# A12 Chelmsford to A120 widening scheme

### **APPENDIX 5.1 SCOPING OPINION RESPONSE TABLE**

August 2022

**FIGURE 6.2**

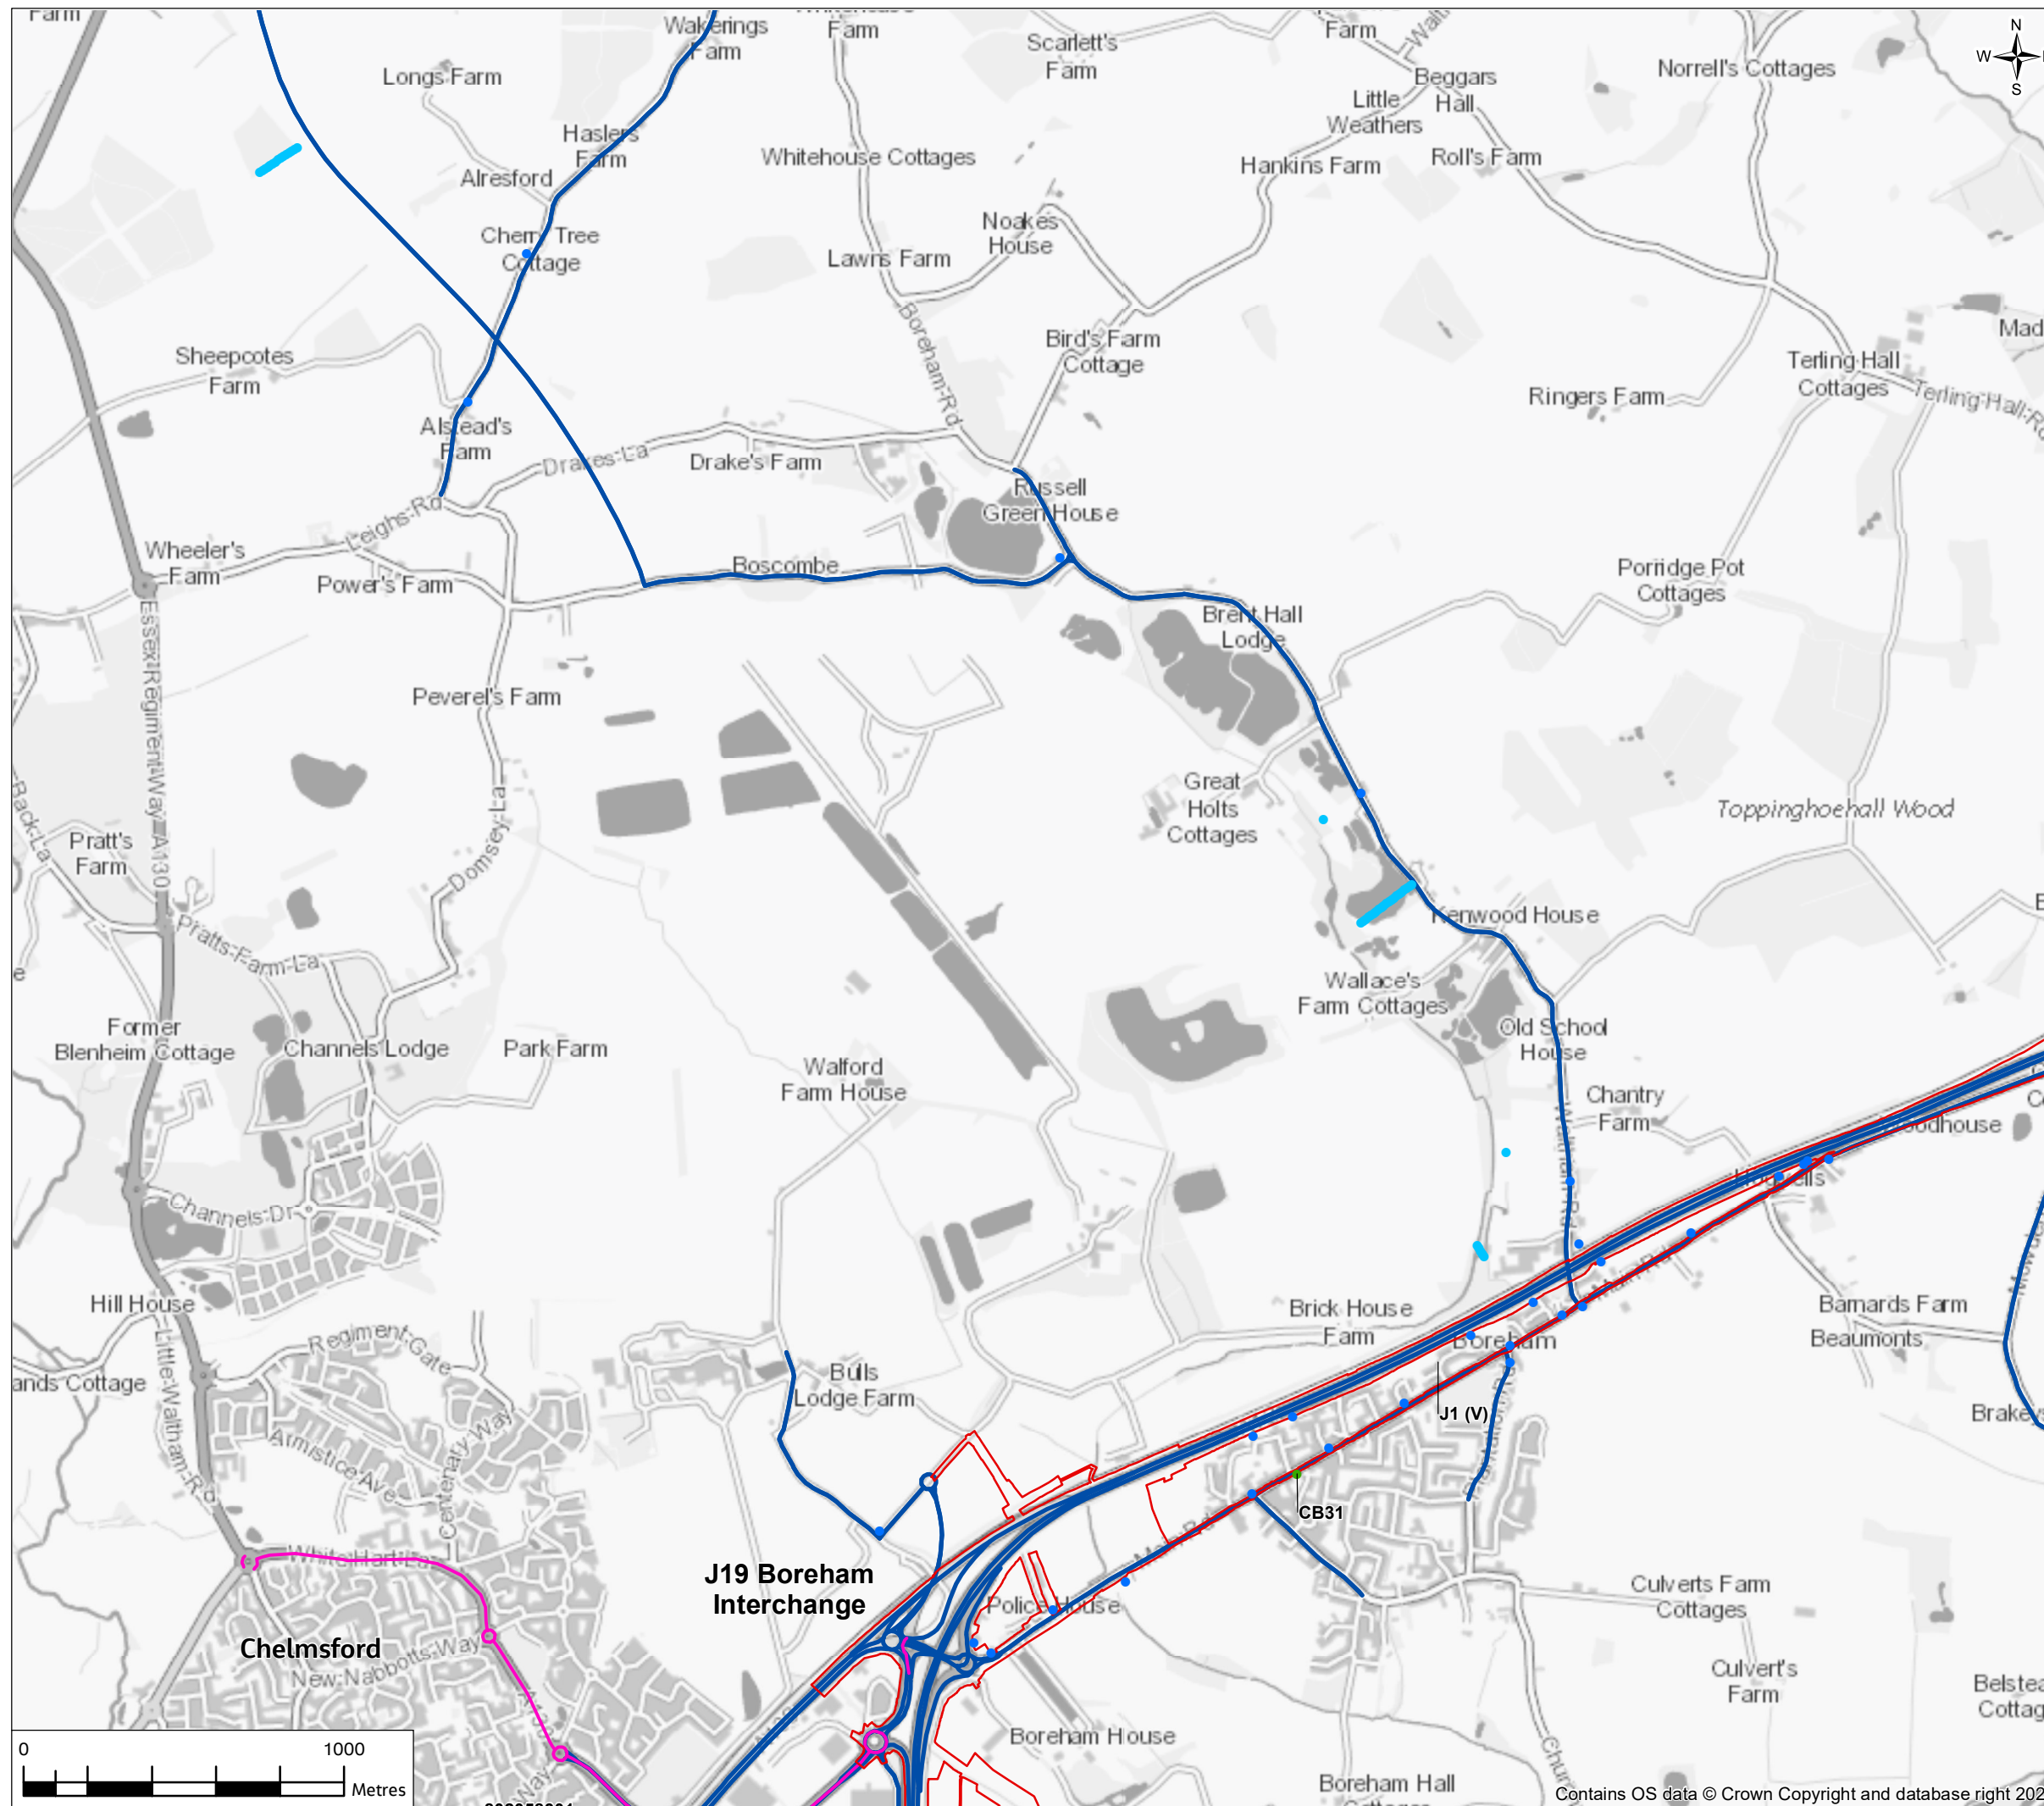
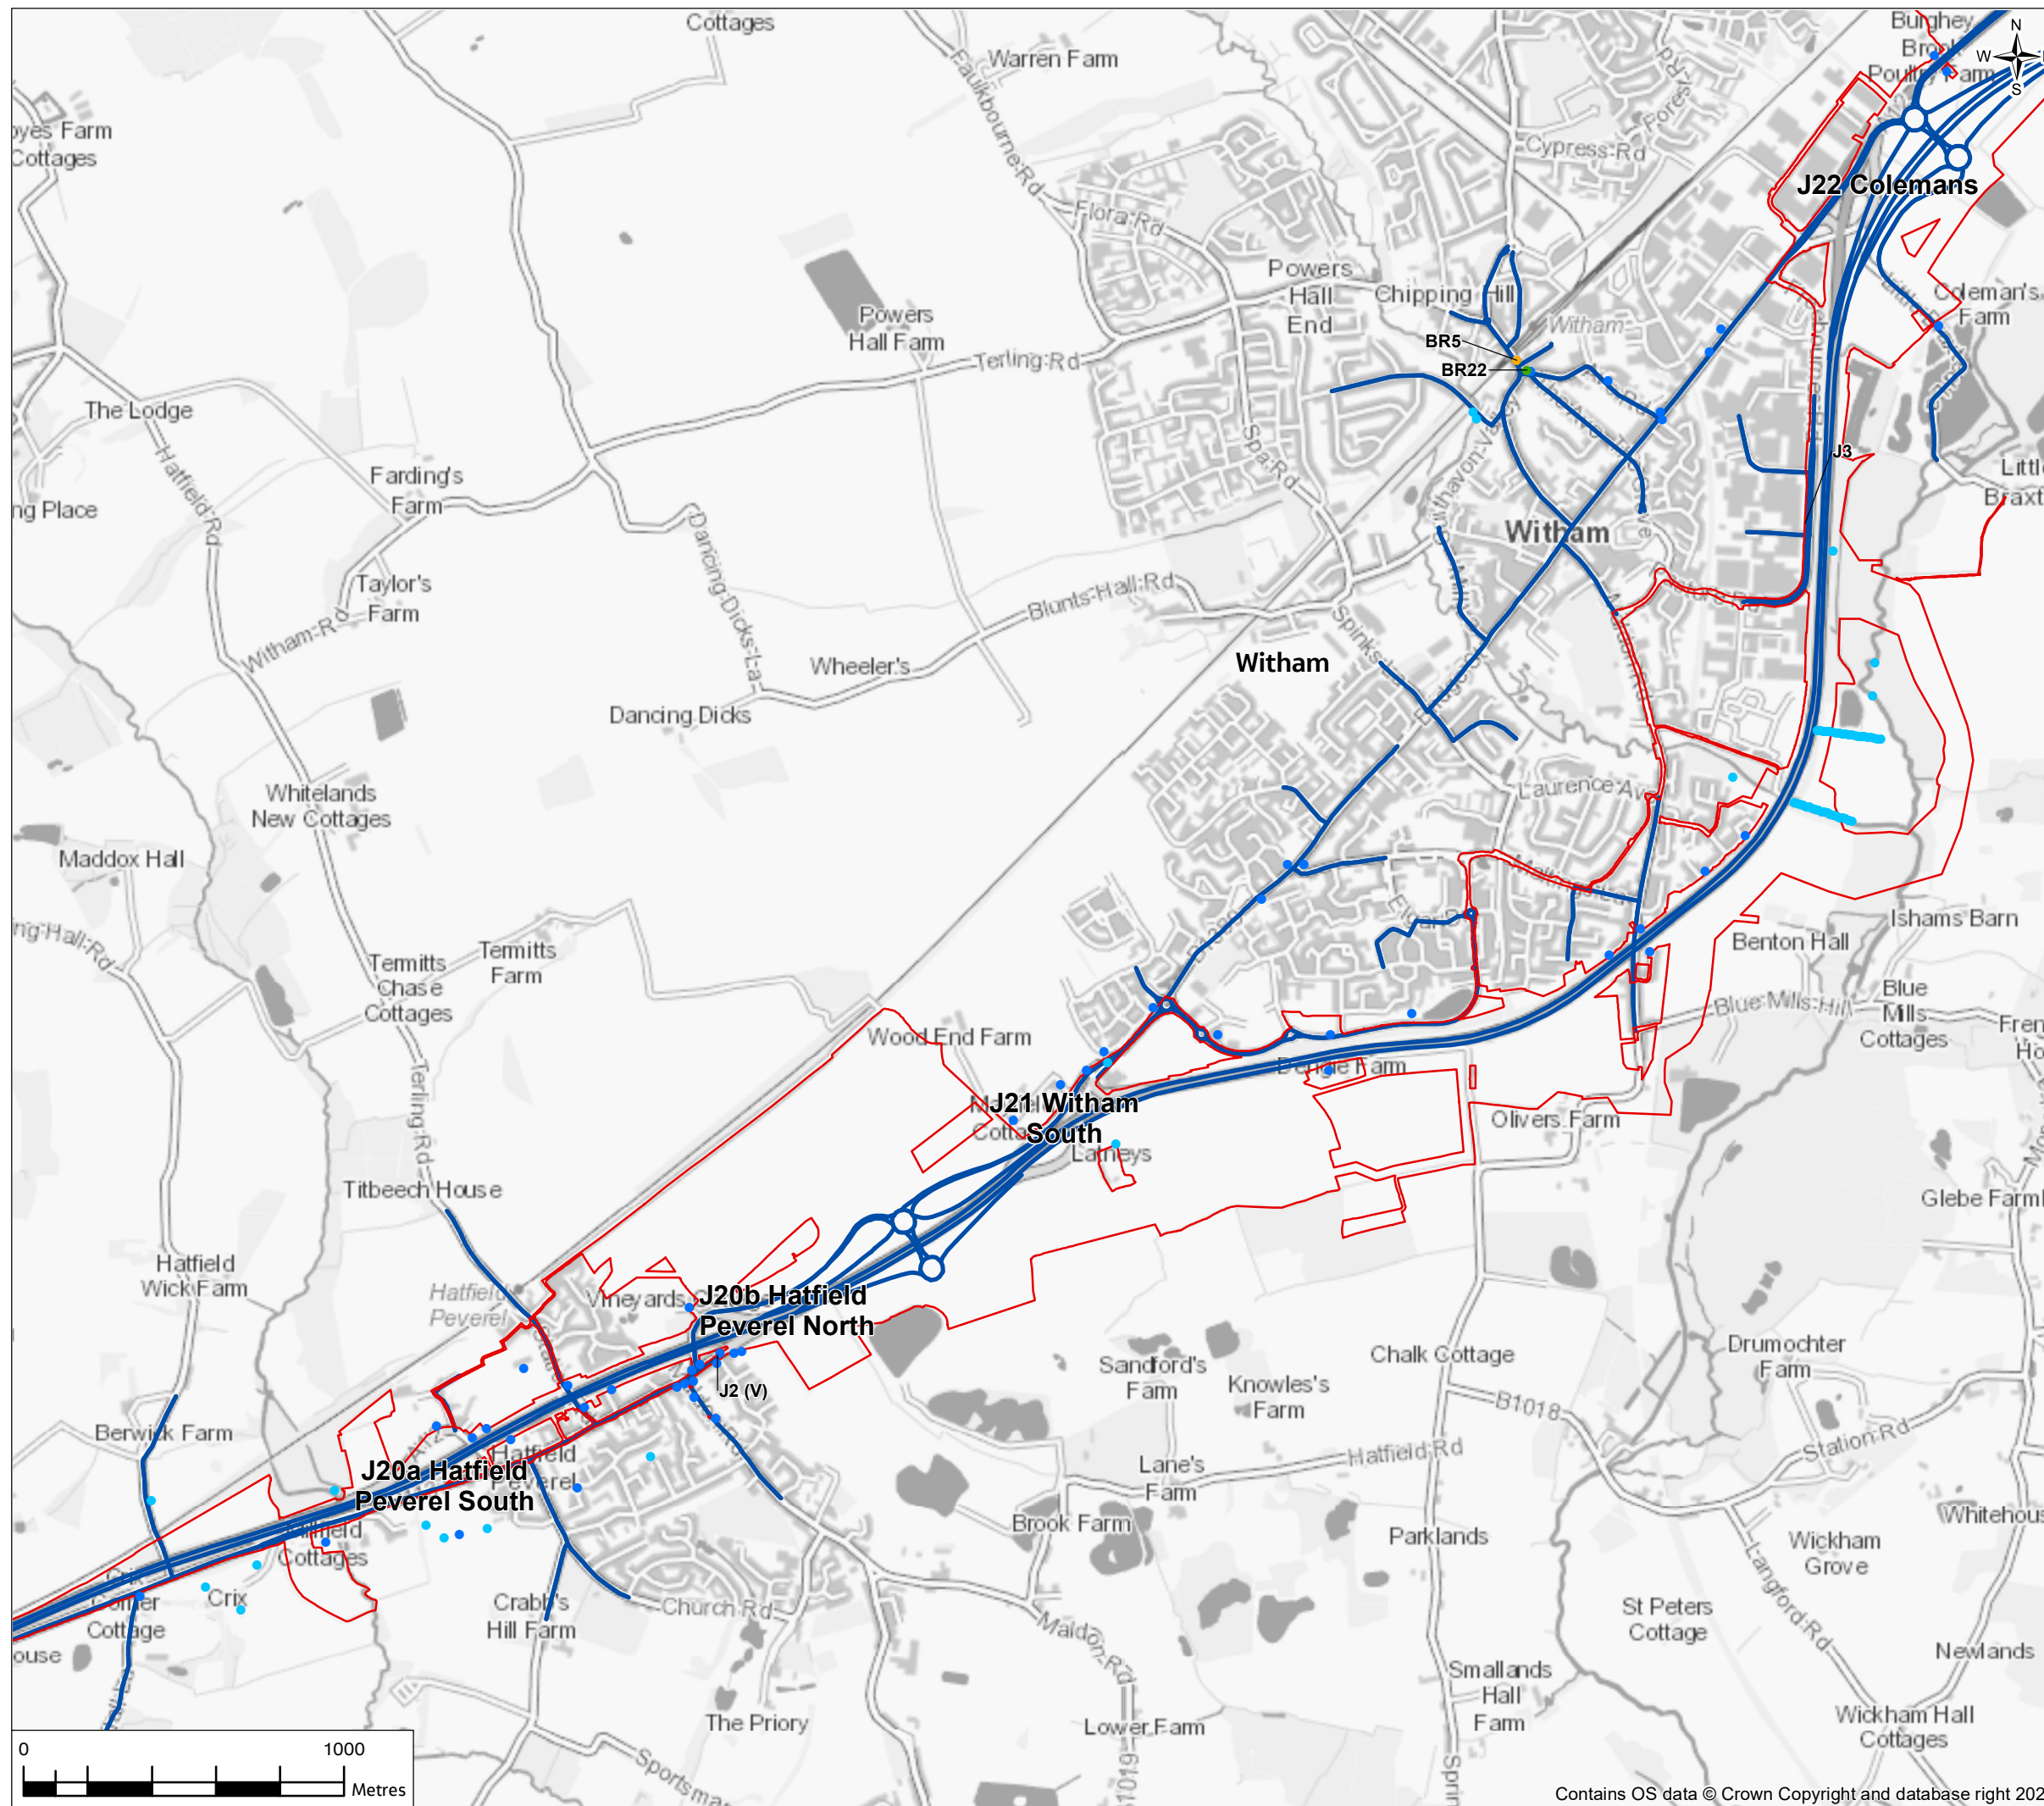
4.1.5	The Highways England monitoring stations, as presented in Table 6.3 and Figure 6.2 of the Scoping Report are not always located close to the Project Control Framework 2 (PCF2) Affected Road Network (ARN). For instance, stations 11, 12 and 13, as shown on Figure 6.2 Sheet 1 of 7, are away from the proposed scheme and the ARN, and Figure 6.2, Sheet 3 of 7 shows no air quality monitoring by Highways England or the local authorities, within Witham. The Environmental Statement should explain the methodology used to determine the locations of the air quality monitoring stations and provide evidence that the locations chosen accurately represent the full extent of the air quality study area.	<p>The study-based air quality monitoring locations were selected to complement existing local authority monitoring and to better facilitate the setting up of the air quality model (e.g. for the purposes of model verification). A representative number of locations were selected near the current and proposed alignment of the A12 to indicate local baseline conditions. Additional monitoring commenced in January 2020 to enhance the existing National Highways sites ahead of the Environmental Statement, but this was discontinued owing to COVID-19.</p> <p>Where data from these sites were not subsequently used for the purposes of model verification, justification for their exclusion is provided in Appendix 6.4: Verification of dispersion model results [TR010060/APP/6.3].</p>
